M54 to M6 Link Road

TR010054

8.5 Formal Request for Scheme Changes

October 2020

DESIGN SPEED 70kph  
(WORK No. 12)  
M54 JUNCTION 1 EASTBOUND MERGE  
LONGITUDINAL SECTION CH. 1000m - CH. 1392m  
SCALE @ A1 - HORIZ 1:1250 VERT 1:250

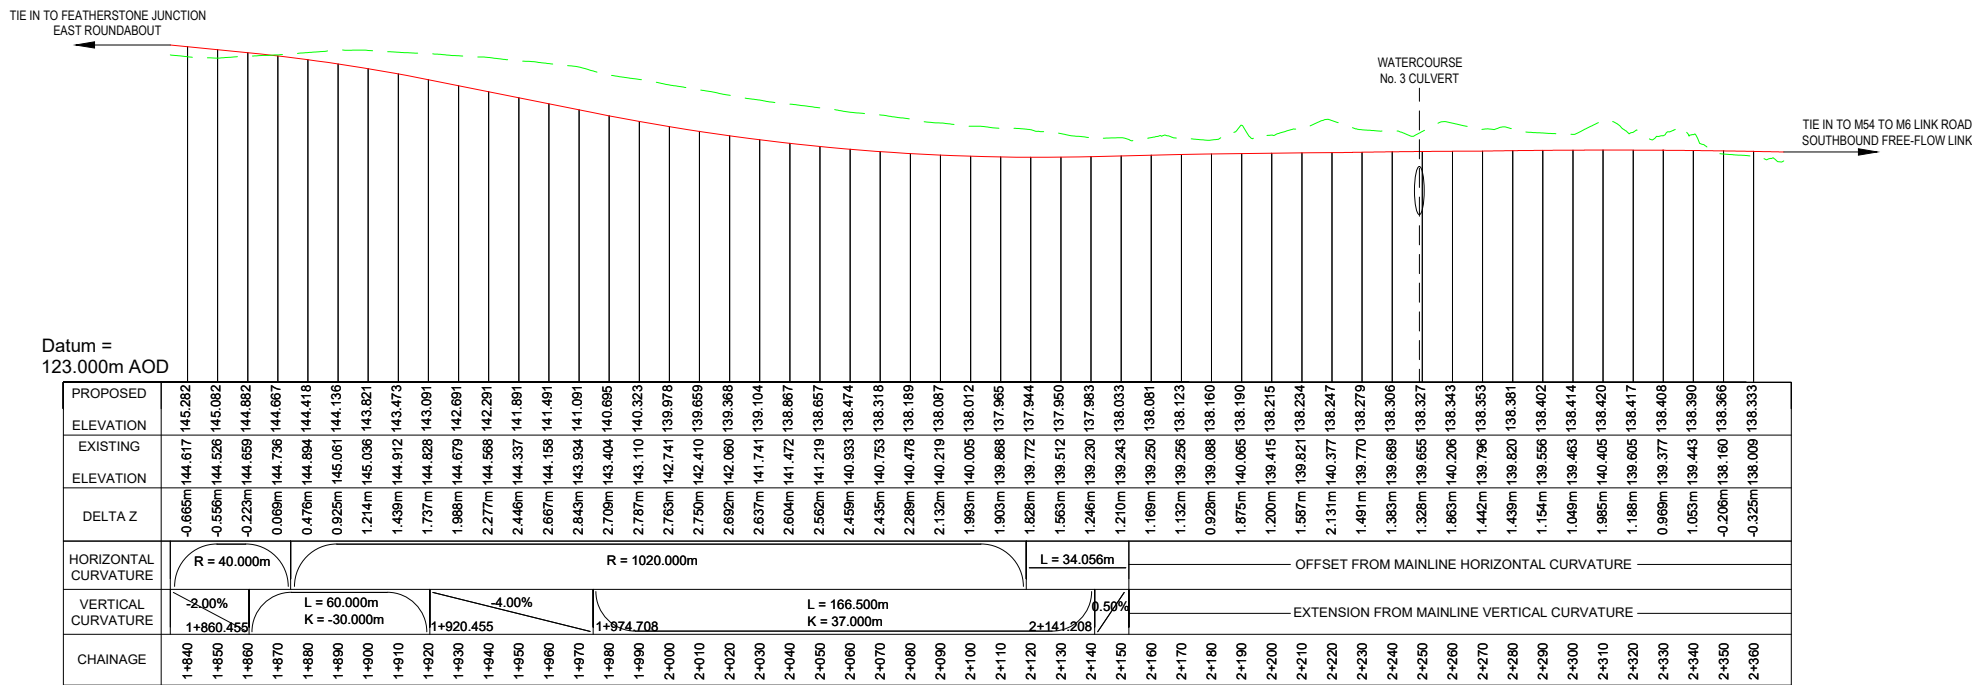
- 2.2.2 This change proposes a minor realignment of the eastbound exit slip road to Featherstone, reducing the length of the slip road to the dumb-bell junction. This will bring the road closer to the junction and reduce the overall size of the junction.

- 2.2.4 The benefits and impacts of this change are:
- The eastbound exit slip road at the M54 Junction 1 will be approximately 10 m further from the village of Featherstone.

- Reduction in the maximum height of the retaining wall associated with work packages 1, 2 and 6 from 5 m to approximately 2.5 m. This would reduce the amount of material required to construct the Scheme and would reduce visual intrusion for road users.

DESIGN SPEED 70kph  
(WORK No. 35)  
M6 J11 SOUTHBOUND DIVERGE  
LONGITUDINAL SECTION CH. 1000m - CH. 1340m  
SCALE @ A1 - HORIZ 1:1250 VERT 1:250

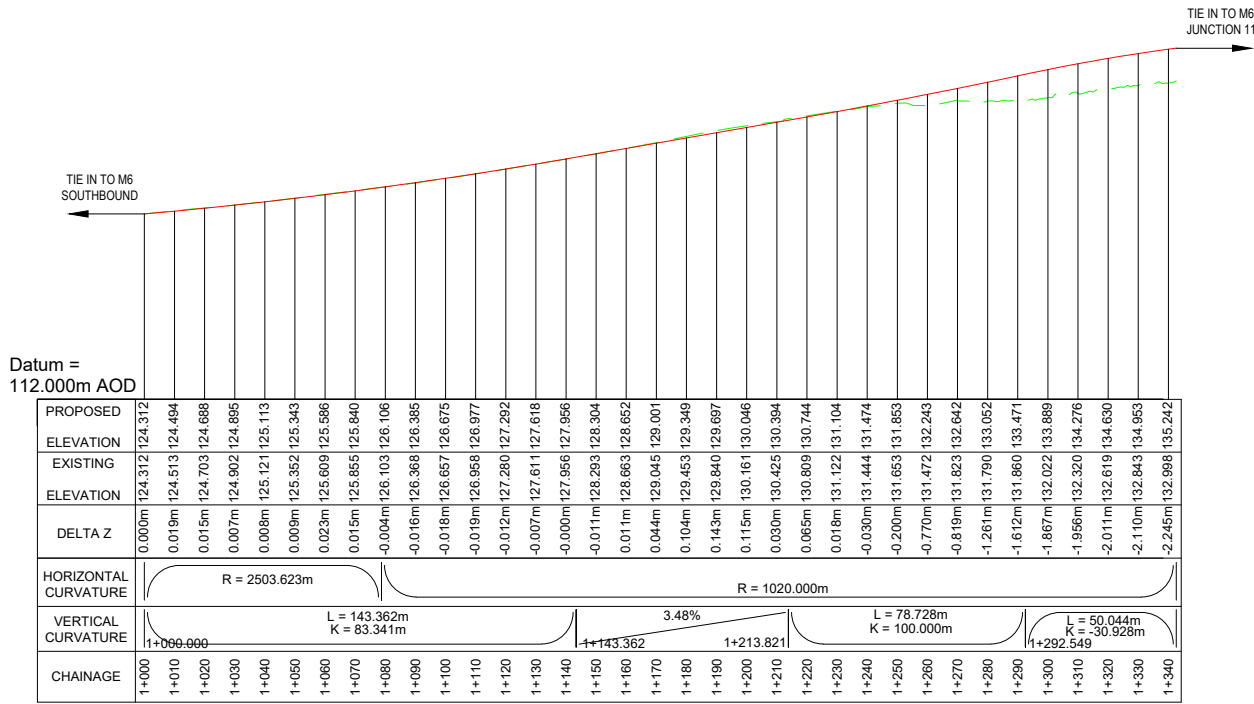
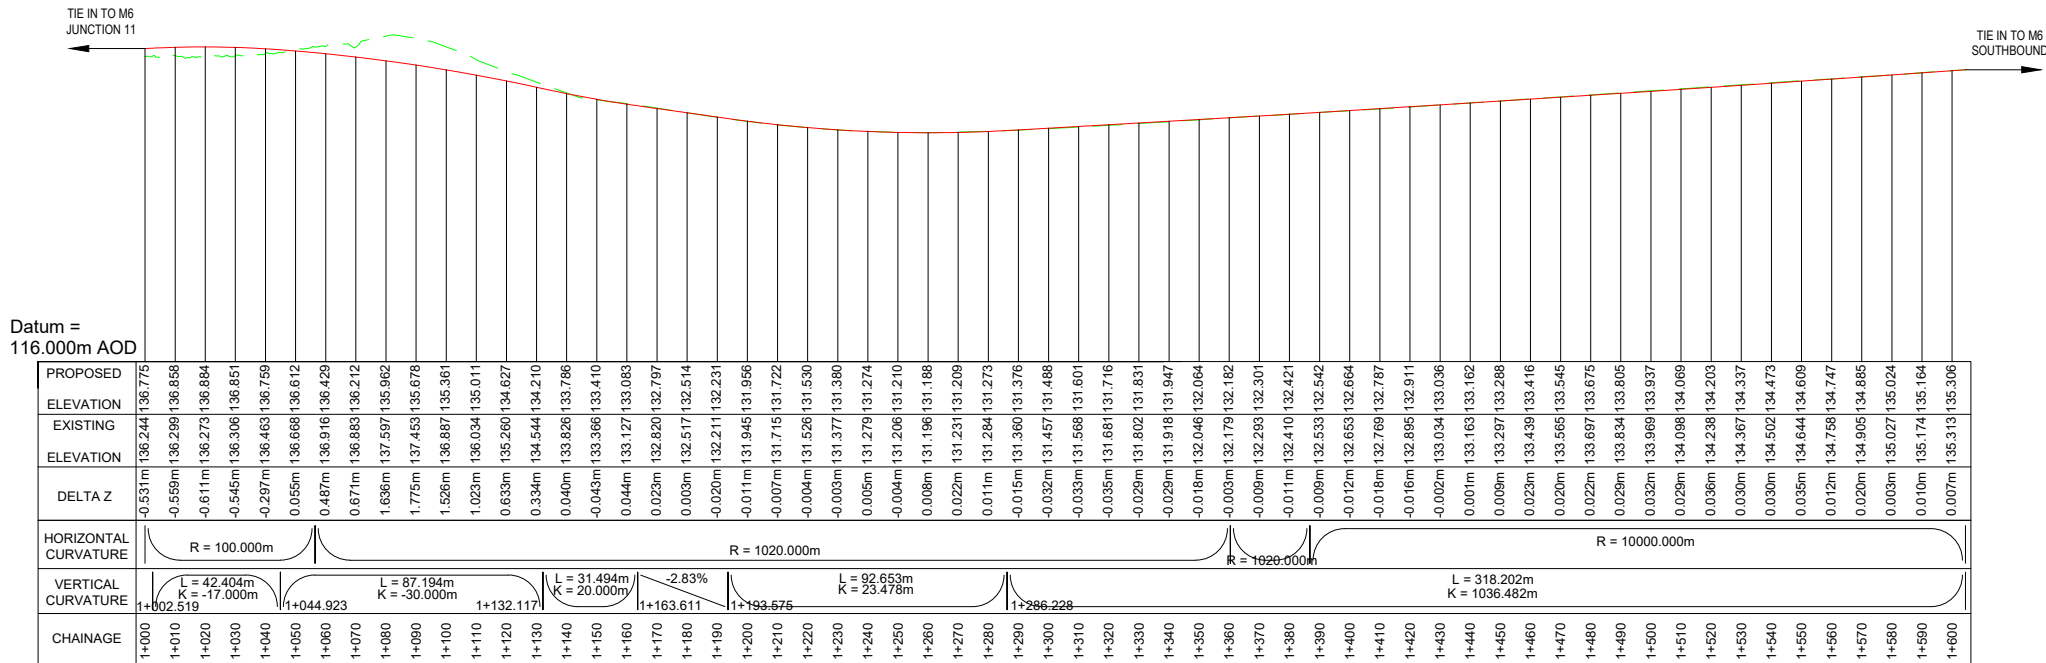
2.4.2 This change would reduce the height of the approach to M6 Junction 11 by approximately 0.7 m where the road passes through an area of woodland near Latherford Brook. This change would increase the gradient of the approach to the Junction. However, the gradient would be within the recommended design for dual carriageway standard, with a maximum 2% gradient at the stop line to reduce the risk of vehicle roll back. Therefore no safety impact is anticipated as a result of this change. A minor change has also been incorporated to the diversion route of Saredon 8 Public Right of Way as a result of changes to the embankment.
